Stage 1 Road Safety Audit Report

Mayo County Council

May 2025

N59 CARROWREVAGH BRIDGE REHABILITATION WORKS

SOUTH ELEVATION
Scale at A1 1:25
Scale at A3 1:50

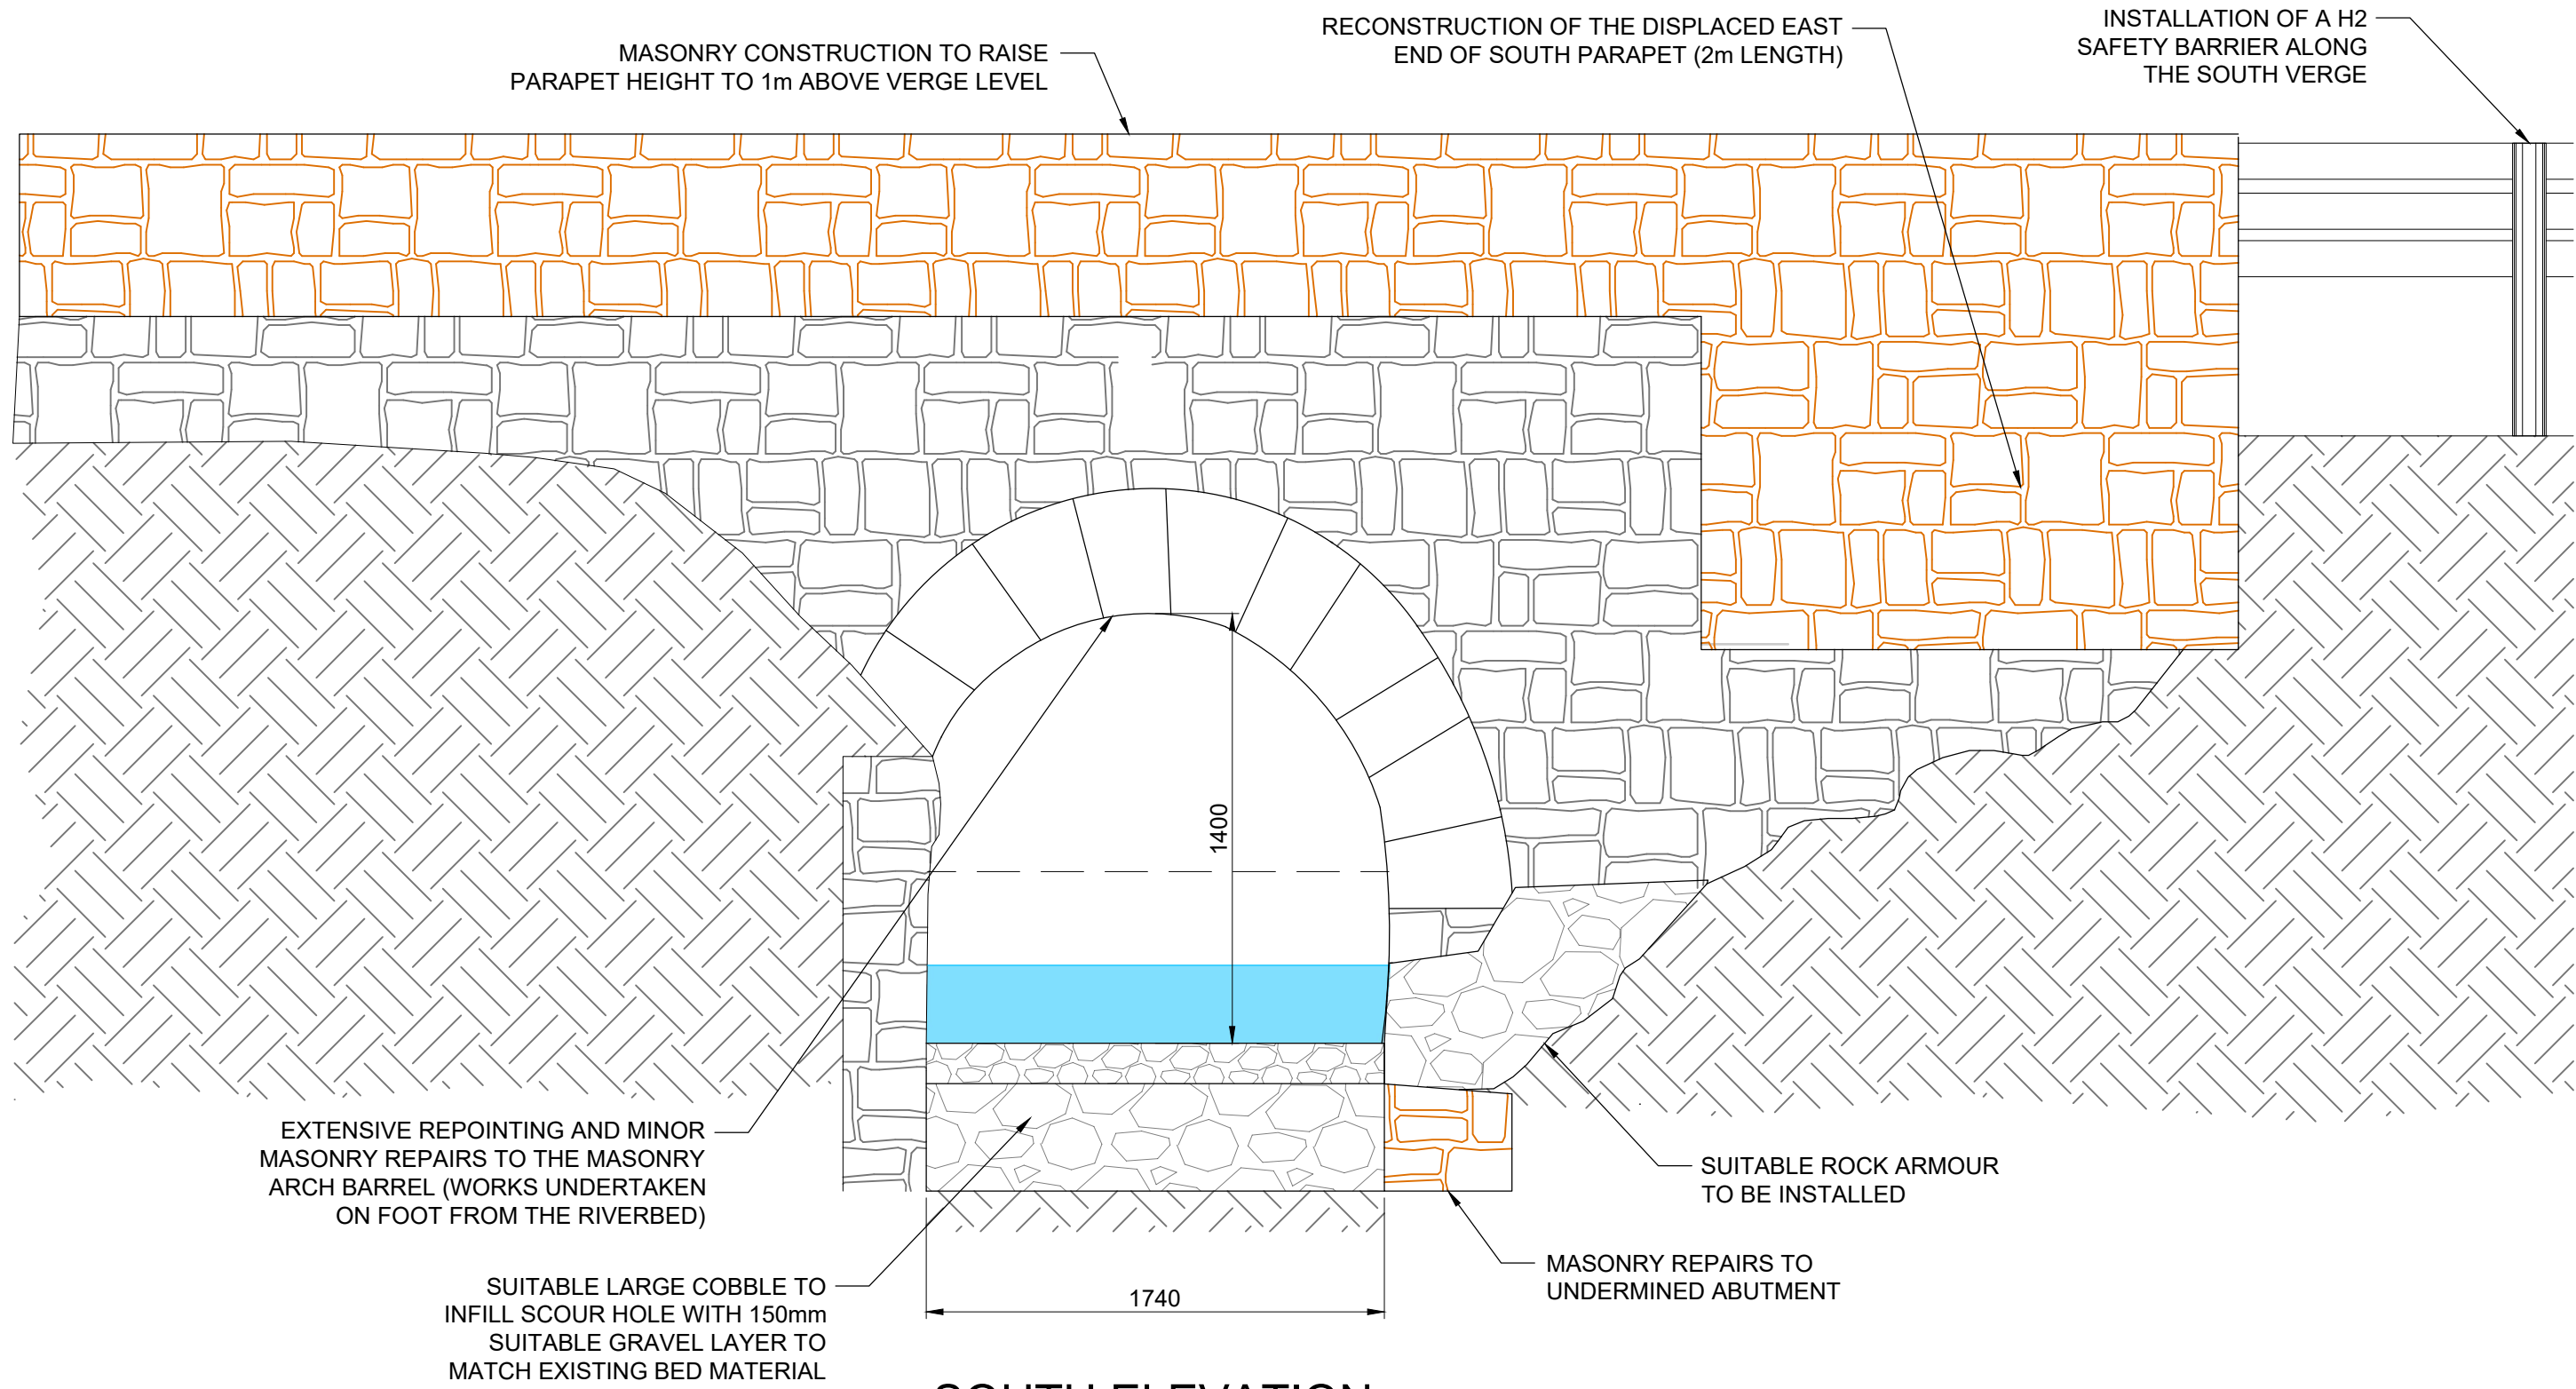
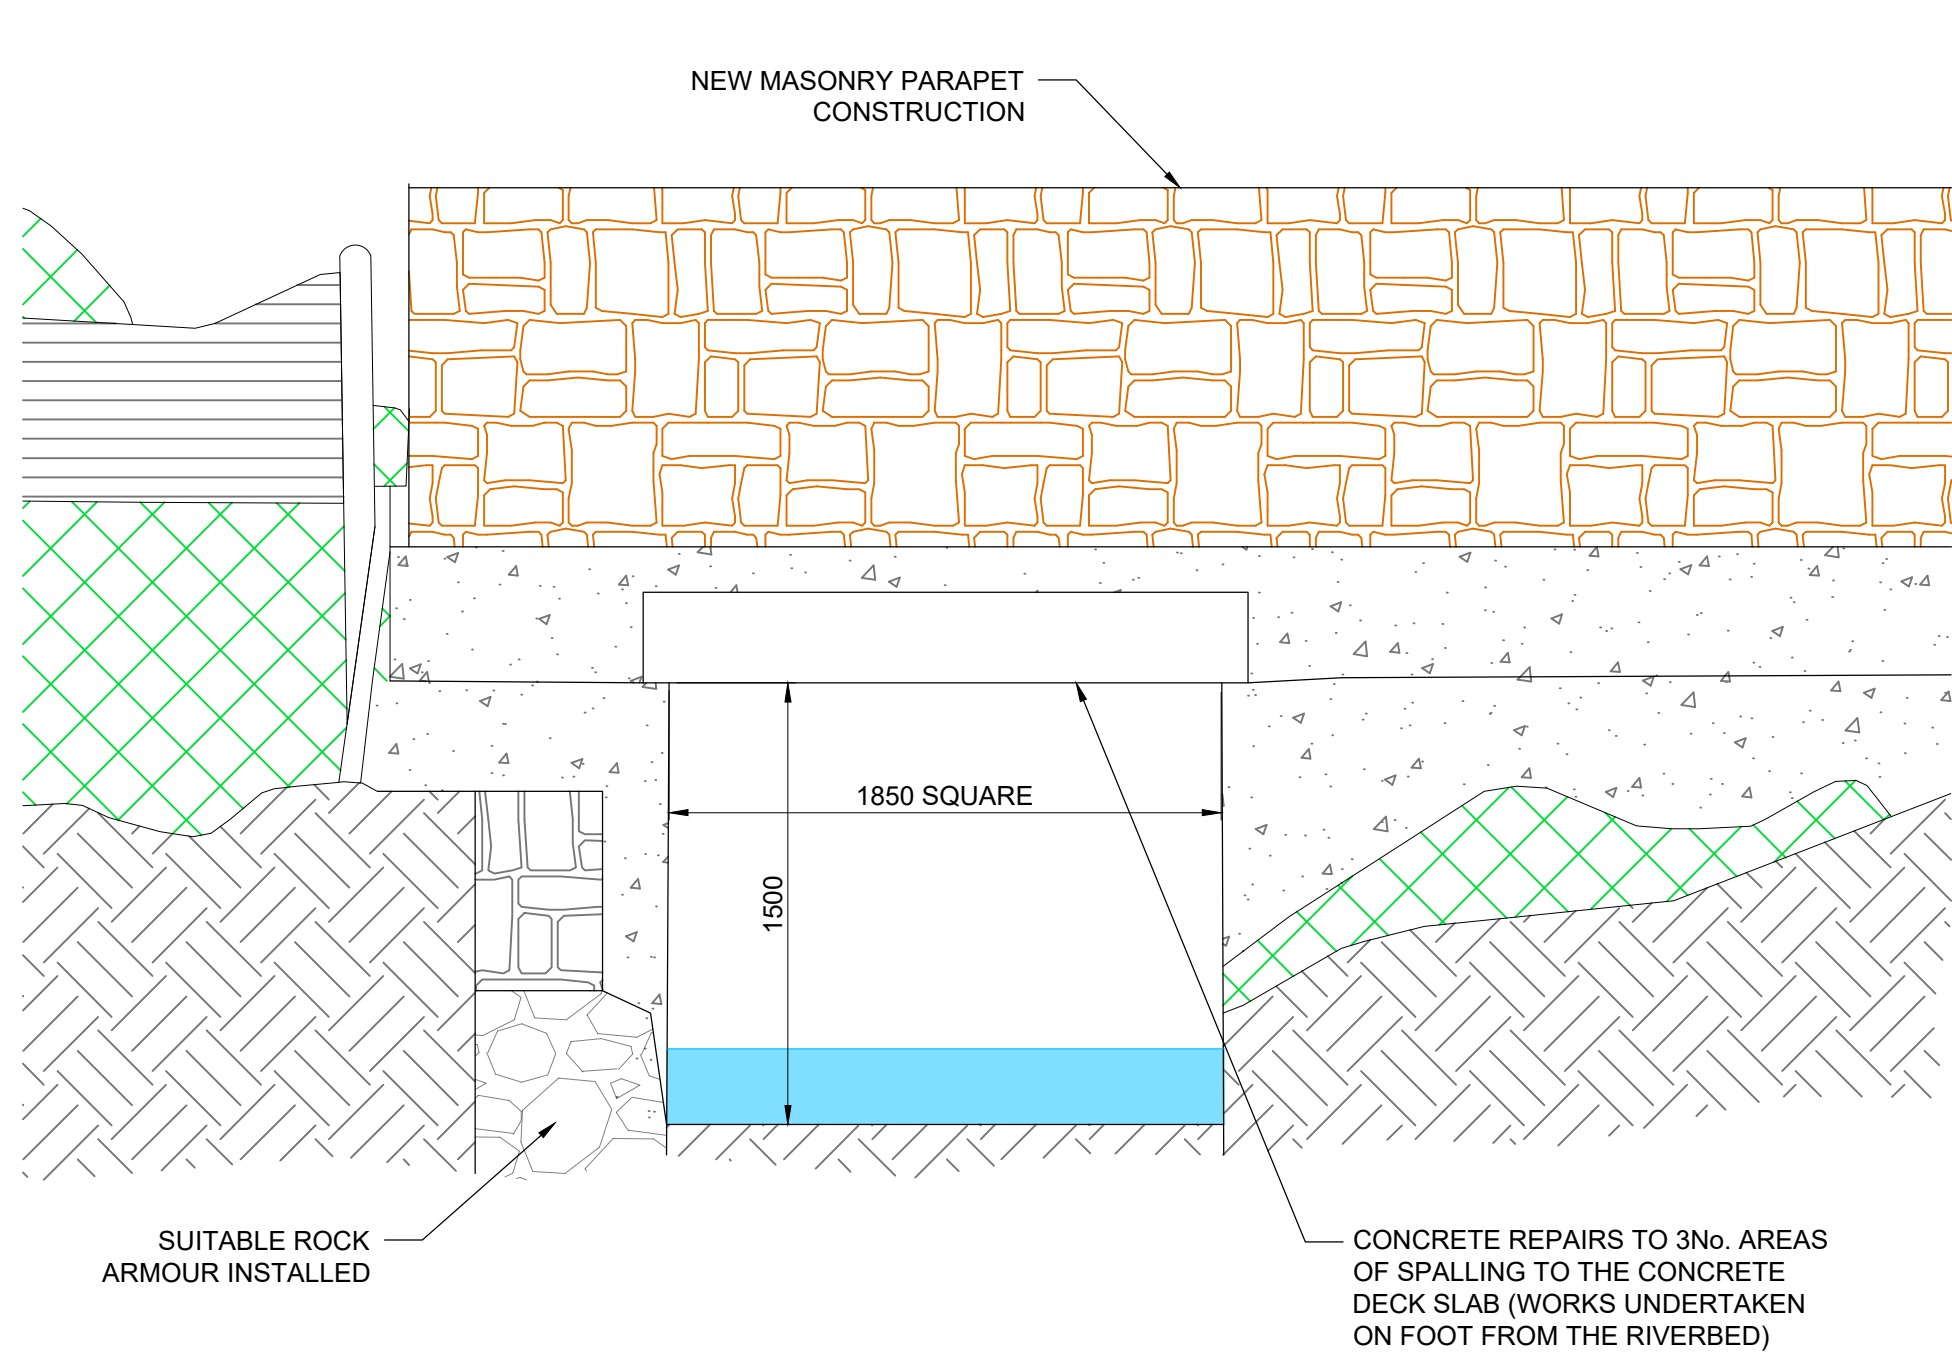
The proposal to raise the existing parapets to a height of 1 metre is not likely to be adequate in preventing pedestrians from falling into the river.

The height of the parapets should be increased to improve pedestrian safety.

2.2	No	No	The proposed 1m parapet height meets the requirements of BS 6779-4 for masonry pedestrian parapets on existing bridges and raising the south parapet height above 1m would impact on existing sightlines from the junction southeast of the bridge. The proposed safety barriers on both verges across the structure also increases the likelihood of the low frequency pedestrian movements being contained to the road edge and the verge areas in front of the barriers.	Yes.
